Hinckley & Bosworth Borough Council
Interested Party Reference Number:
20039546

Deadline 4 Submission:
Response to Sustainable Transport
Strategy & Plan (REP3 – 016)

Application by Tritax Symmetry
(Hinckley) Limited for an Order
Granting Development Consent for the
Hinckley National Rail Freight
Interchange

(ref. TR050007)

Figure 8: Existing Bus Services

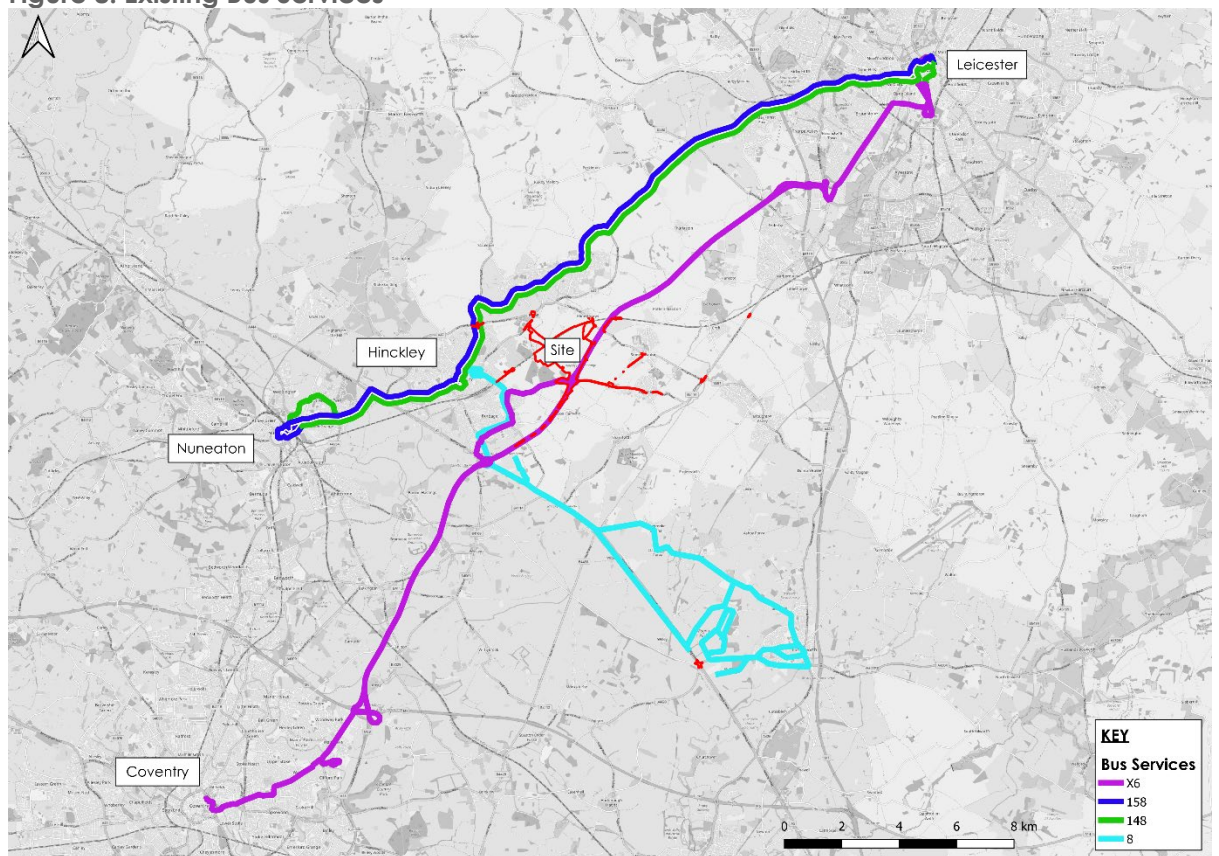
- d. In terms of bus services, the applicant has introduced the Arriva 8 service between Hinckley and Lutterworth as a suitable existing service that the site could rely on. It is noted though that this service is not shown in figure 9. However, whilst this service runs to and from Hinckley bus station and has stops in Burbage, its destination is Lutterworth via Magna Park, which runs nowhere near the HNRFI site itself, so it is difficult to understand how this benefits the site. None of the services the applicant relies upon give direct access to the HNRFI site and do not connect the local communities into the site and the strategy fails to provide any clear proposals for enhancements to any existing services to connect the HNRFI site to them. The outcomes of the discussions with the bus operators are 'wooly' at best and offer no certainty as to what is actually being proposed and again para 3a above is referenced.

Figure 13: Future HNRFI Public Transport Network

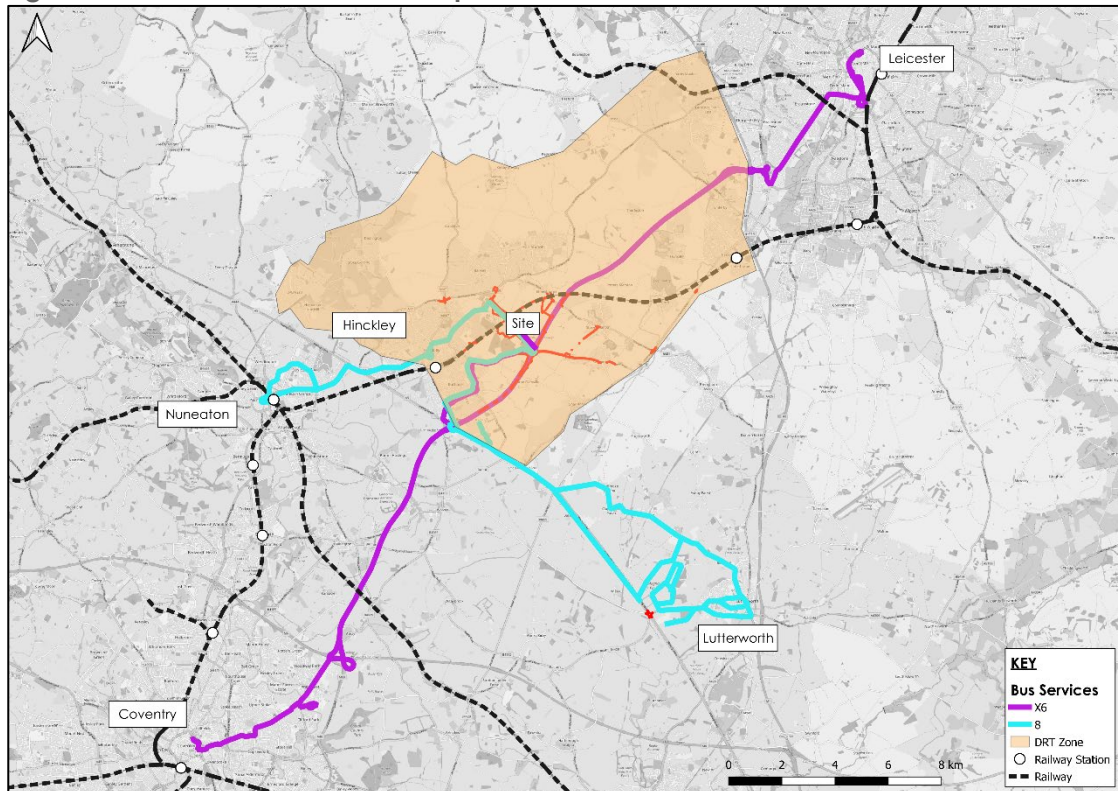
- f. Table 6 and Figure 14 set out the proposed bus strategy; it is clear from Figure 14 that there is extremely limited provision proposed from the large urban areas of Hinckley/Barwell/Earl Shilton. Services 8 and 158 are still a significant distance from the site, and there is no clear picture of what will be provided and how it will be secured. If bus to bus interchange to the site is planned, what time constraint will that impose on passengers? Dependence on DRT services (for Hinckley or villages) is not regarded as a viable option in that the level of service is not set out, and most experience of DRT services is that they fall away after subsidy runs out. DRT is also unlikely to be sufficiently responsive to meet multiple conflicting demands from different locations by passengers wanting to get to or from the site at the same time due to the shift patterns. There is also mention of internal shuttle bus services taking staff from bus stops into the development itself, but no clarity as to if this is a definite proposal and how it will be secured.

Figure 14: 2km Walking Catchment Area

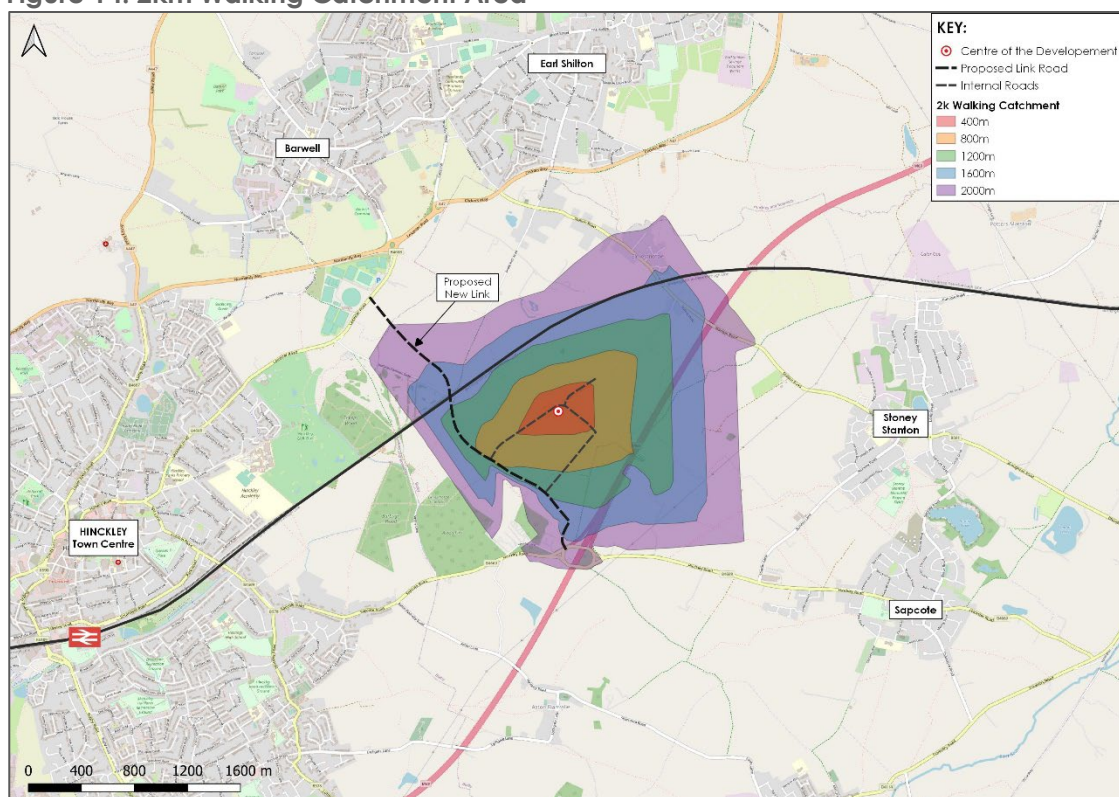
- h. Regarding walking to the site, the accuracy of the figure 15 2km isochrone is queried as it does not appear to accurately depict the distances from the site. This brings into doubt the accuracy of para 8.3's assertion that there is little population within walking distance of the site. The screenshot below shows a distance of 2km from the centre of the site with the yellow line.
